**DELEGATED DECISION TO DETERMINE APPLICATIONS FOR
NON-MATERIAL AMENDMENTS**

Reference No: 2020/NM/92080/W

Site Address: 120, Laund Road, Salendine Nook, Huddersfield, HD3
3TY

Description: Non material amendment to previous permission
2019/90486 for demolition of existing dwelling and
erection of 7 dwellings

PLOT 2 ELEVATIONS

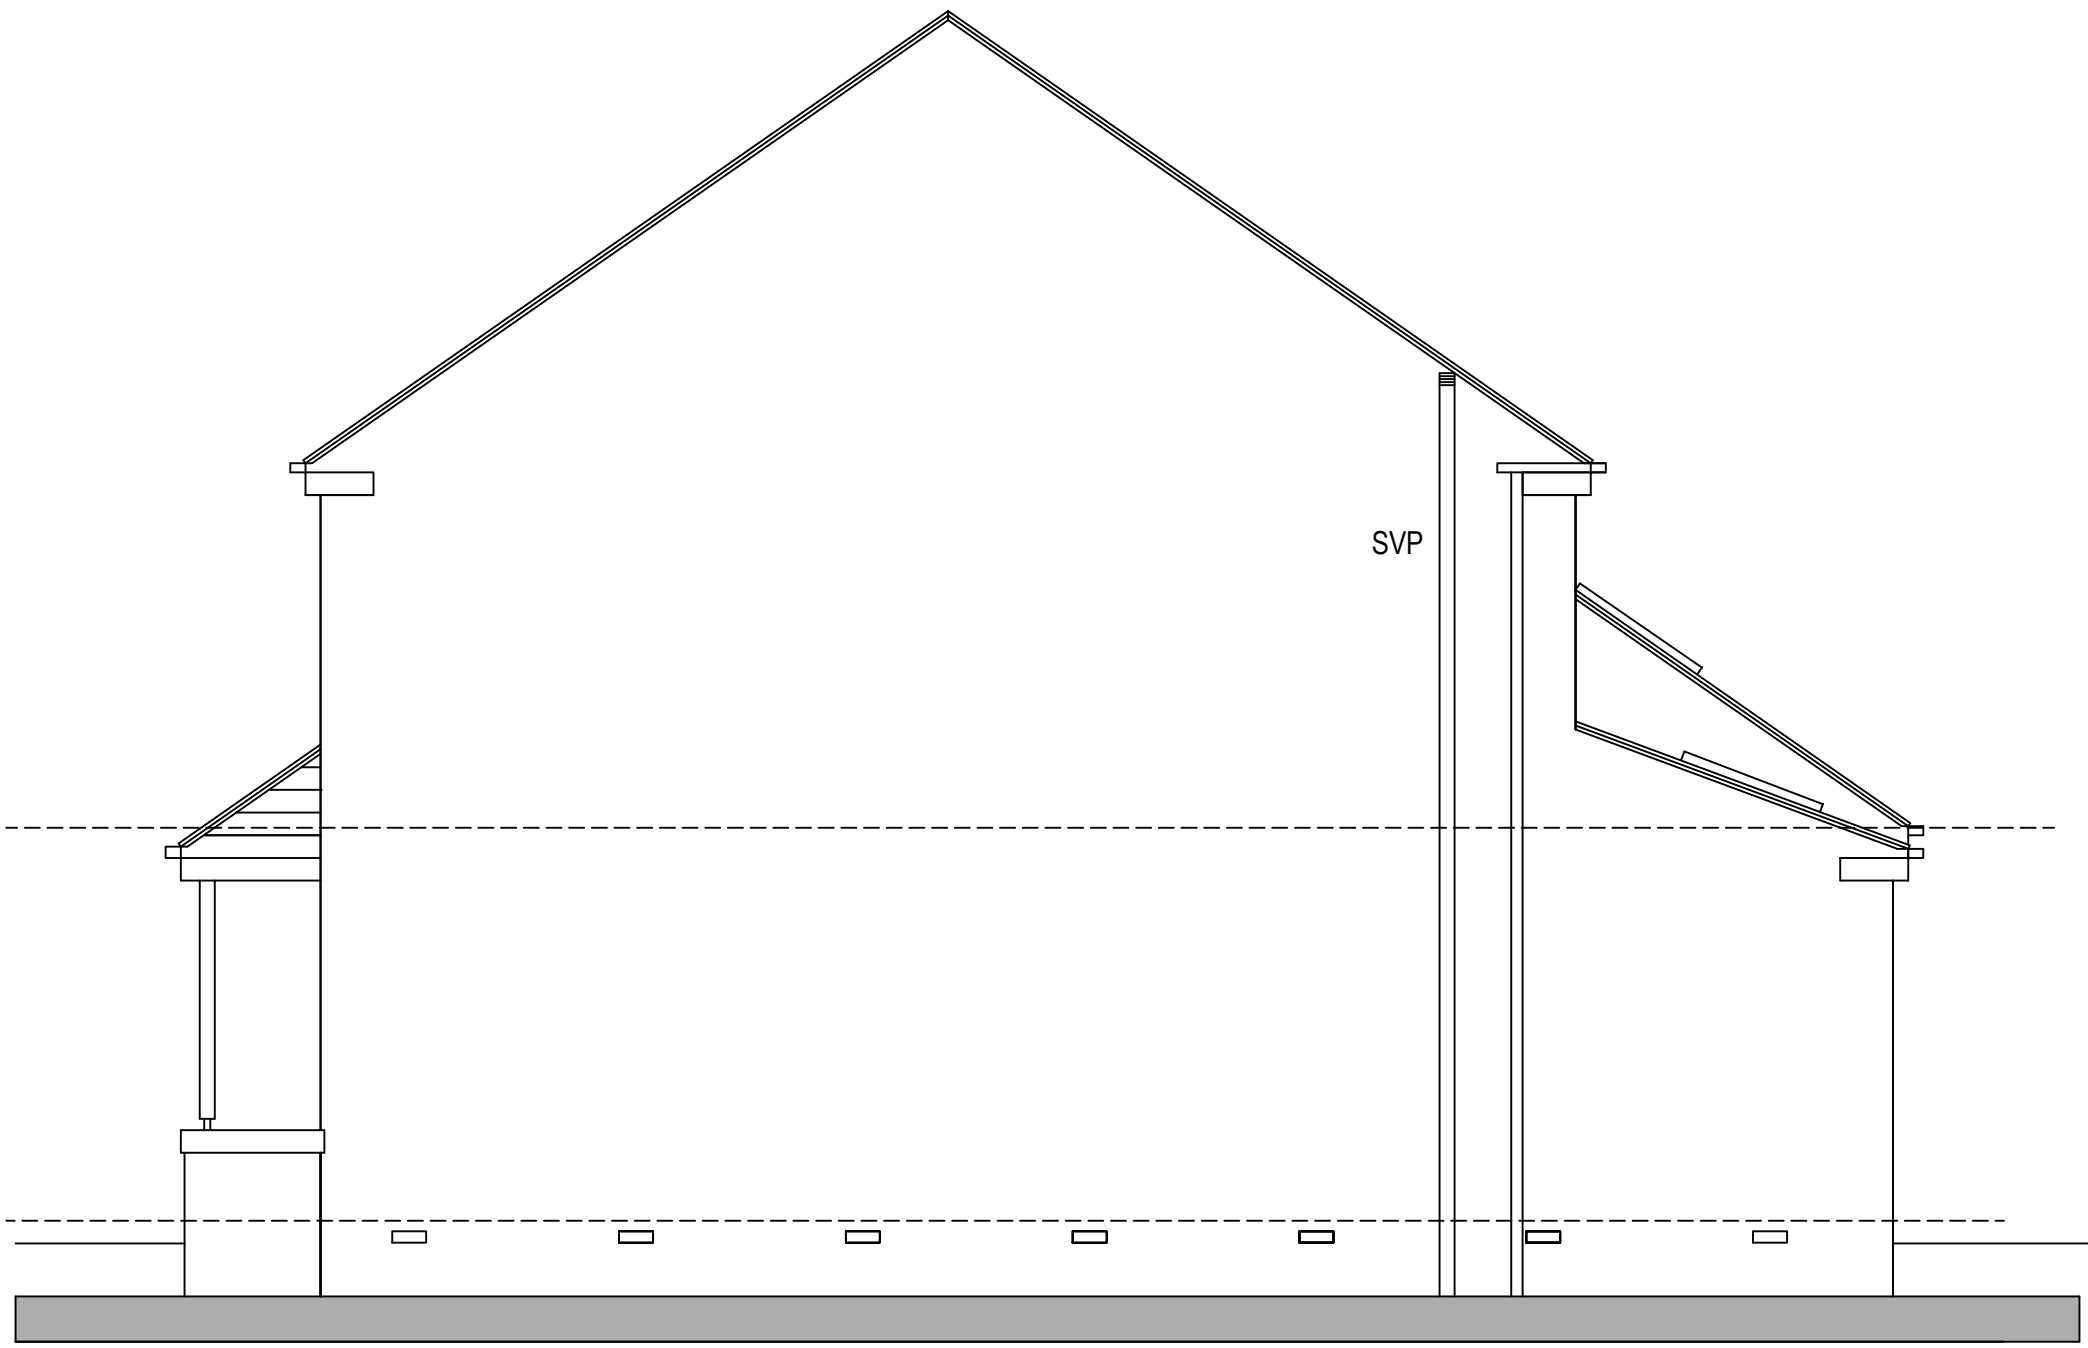
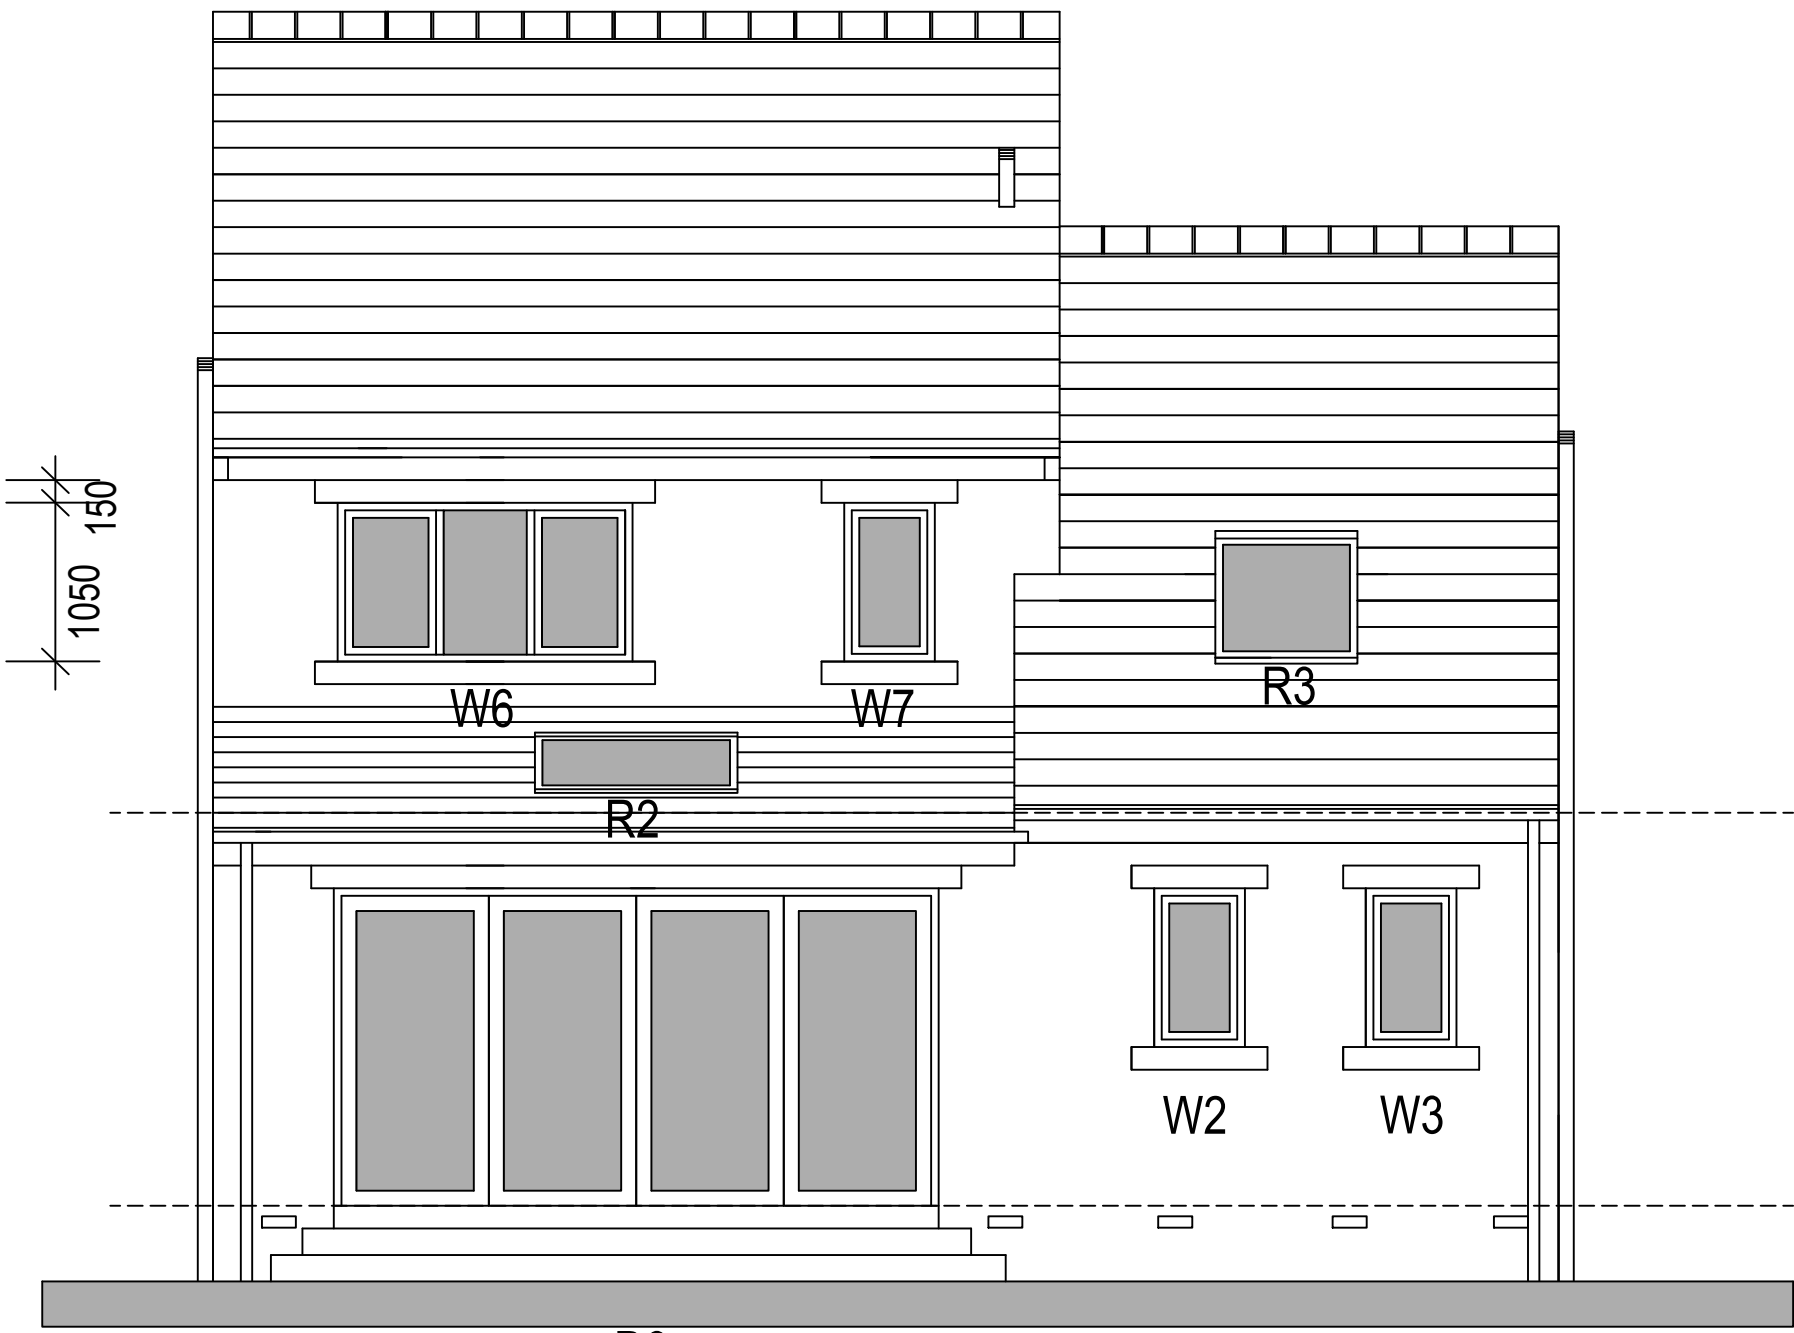
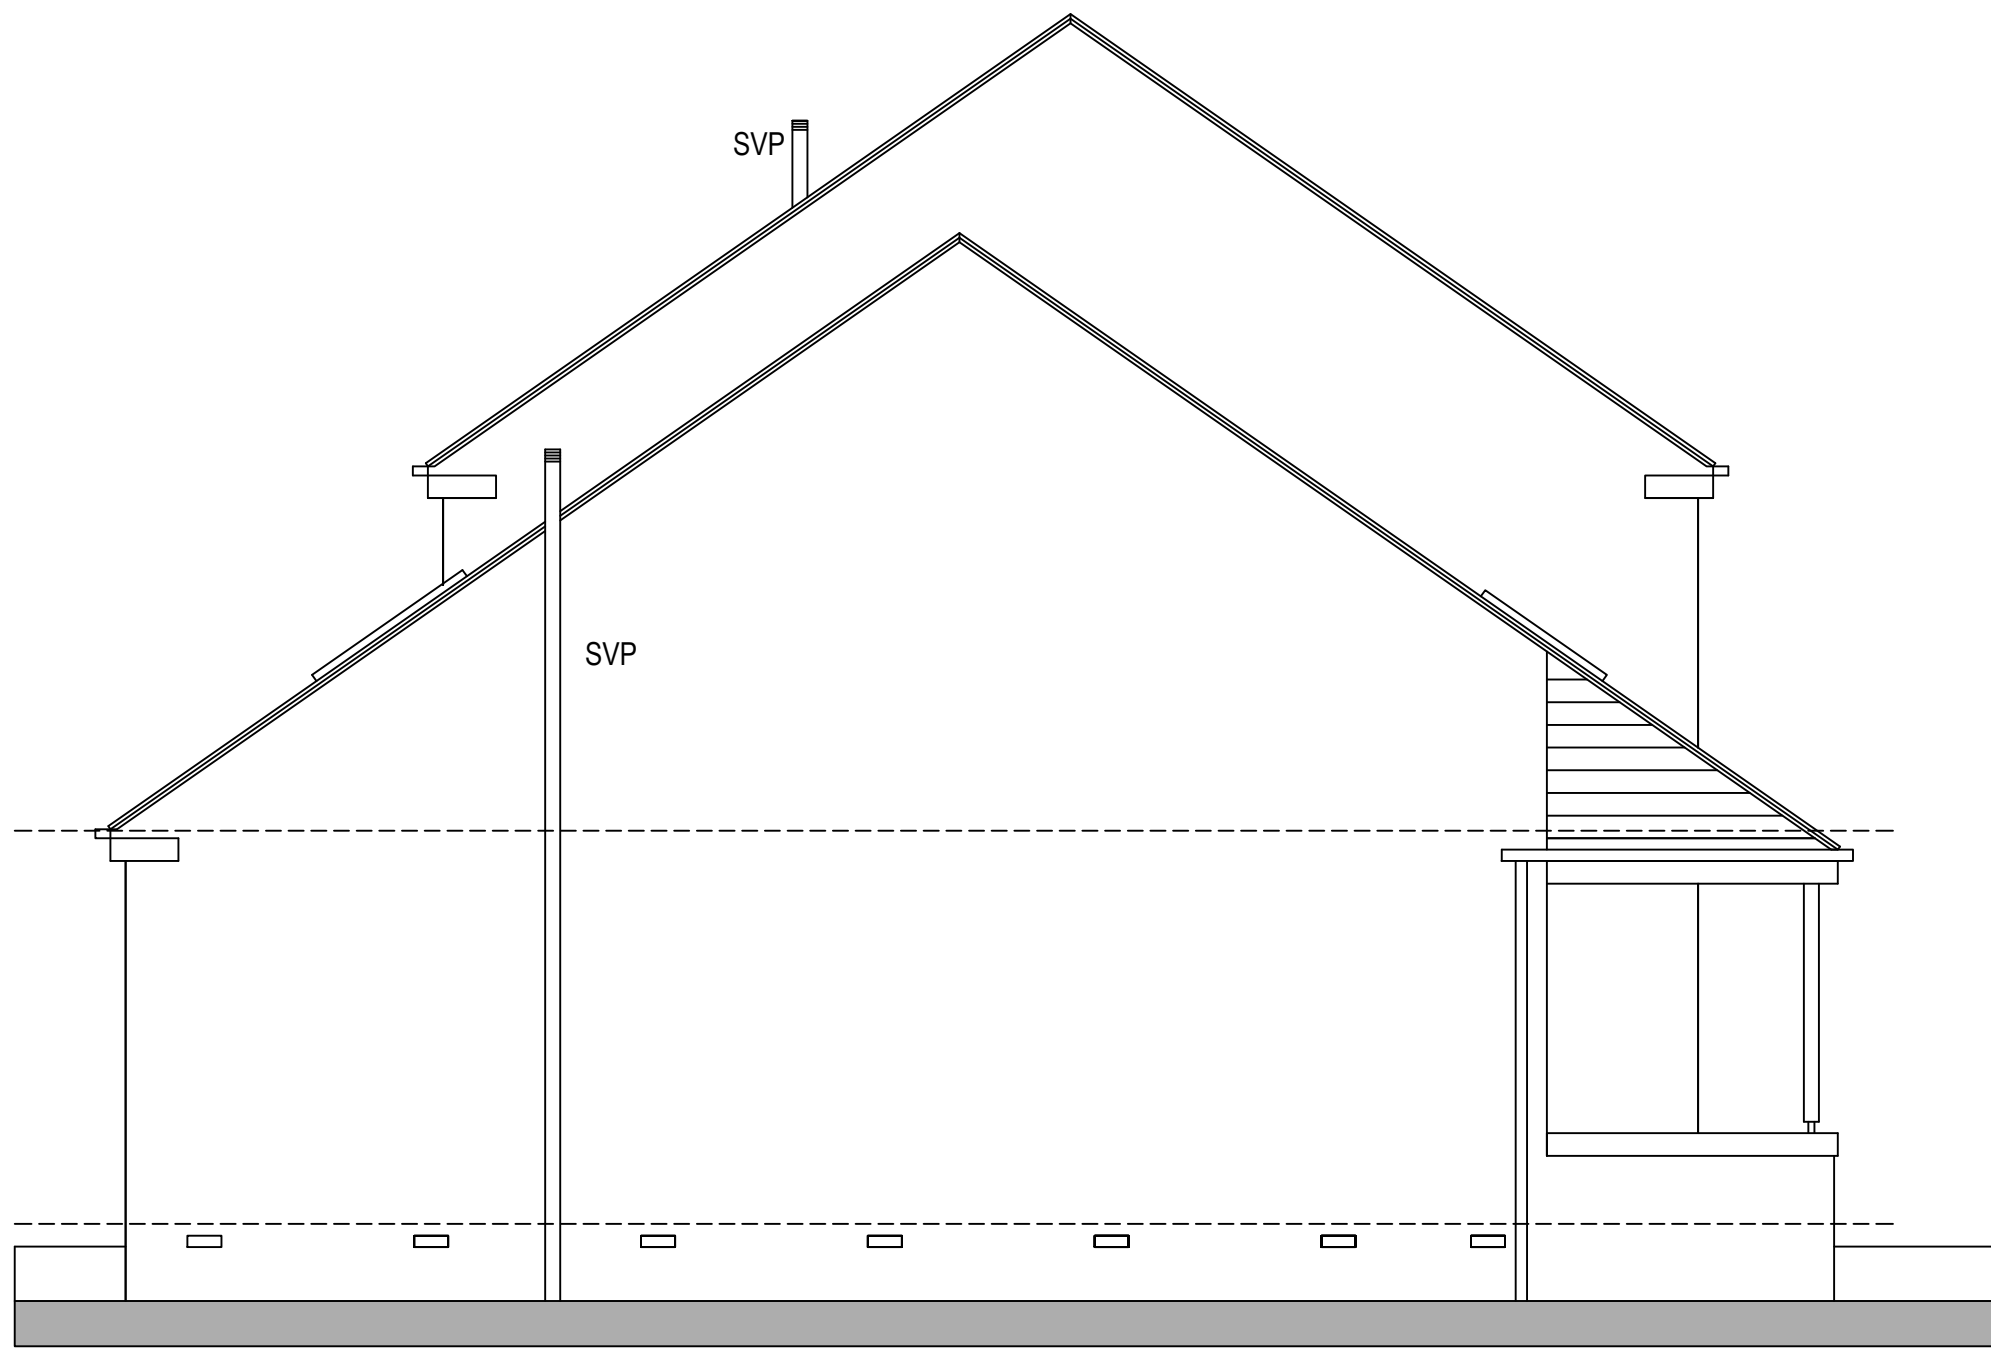
- The increase in overall height of plot 2 by 350mm.

Yes. Whilst the proposal would increase the overall height of the building it is considered that a 350mm increase would be minor when compared to the overall height of the dwelling which would be 8.1 metres.

No, the increase in height would not have a material affect the appearance of the dwelling and it would retain an acceptable design which would preserve the character and appearance of the dwelling and wider local area and would not lead to any additional detrimental impact on living conditions.

No. The alteration is considered to be inconsequential; whilst the height of the dwelling would be increased, it is not considered that the very limited overall scale would not lead to a detrimental overshadowing or overbearing impact on any of the adjacent properties.

No, whilst the overall height is to be increased by 350mm it is not considered to 'materially' larger and as set out above the proposal is considered to have an acceptable impact on visual and residential amenity.

- The increase in overall height of plot 2 by 350mm.

This amendment is set out on the following drawings, Site Plan Dwg. No. 02 Rev B, Proposed Elevations Dwg. No. 11 Rev A, Proposed Floor Plans Dwg. No. 10 Rev A.
